Subject: RE: 2023/62/91649/E Demolition and Rebuild of Boundary Wall - 11 Wood Street, Skelmanthorpe

Biodiversity Officer

Tree Constraints Plan
11 Wood Street, Skelmanthorpe

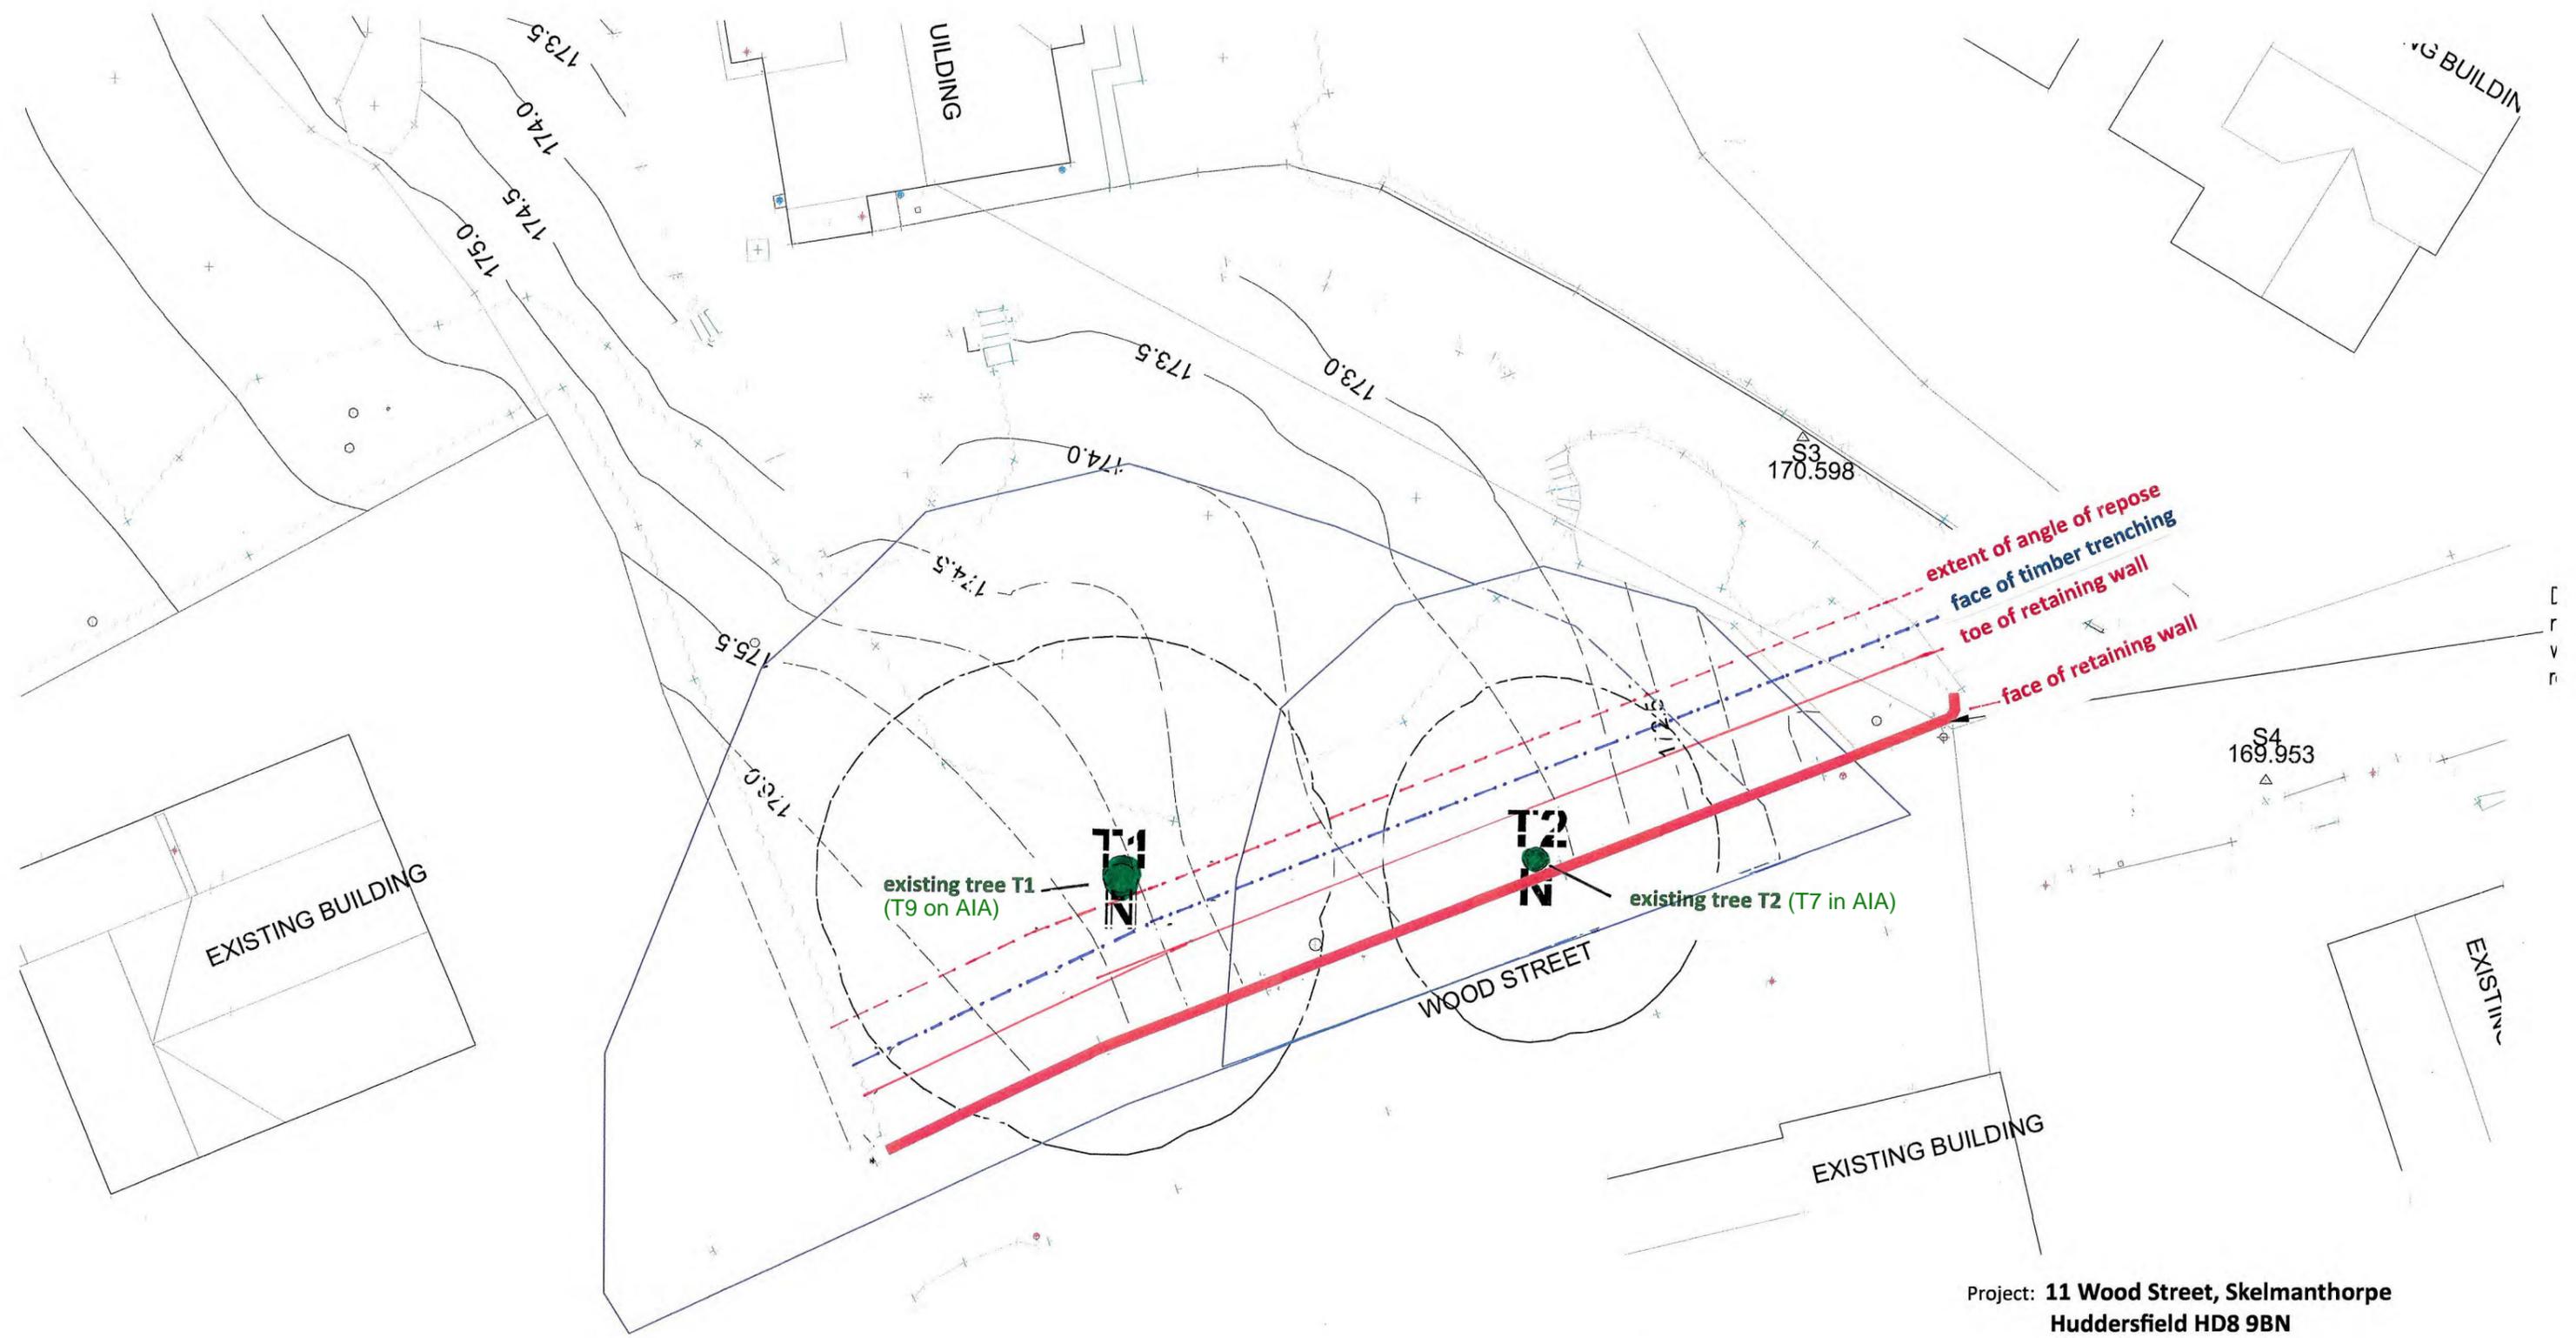
Following on from my previous comments, additional communications have been reviewed and these update comments supersede the previously submitted ones. The site is located within the bat alert layer. At this stage, it is unclear whether the trees (particularly those to be lost to the proposed development) present within the site offer suitable roosting opportunities for bats.

In addition to bats, the trees on site that are scheduled to be removed are likely to provide suitable habitat for nesting birds.

The trees on site that are due to be removed are likely to provide suitability for nesting birds. It is recommended that these trees are inspected by a suitably qualified ecologist, prior to their removal.

The applicant should engage with a suitably qualified ecologist to undertake a bat scoping survey of the trees on the site. The survey should be undertaken in accordance with methods outlined by the Bat Conservation Trust (BCT) and Bat Roosts in Trees (Bat Tree Habitat Key (BTHK), 2018). The report of the above should cover whether there are potential impacts to roosting, commuting and foraging bats during and post-development i.e. as a result of new lighting provisions, due to the location of the site as a potential commuting route for bats.
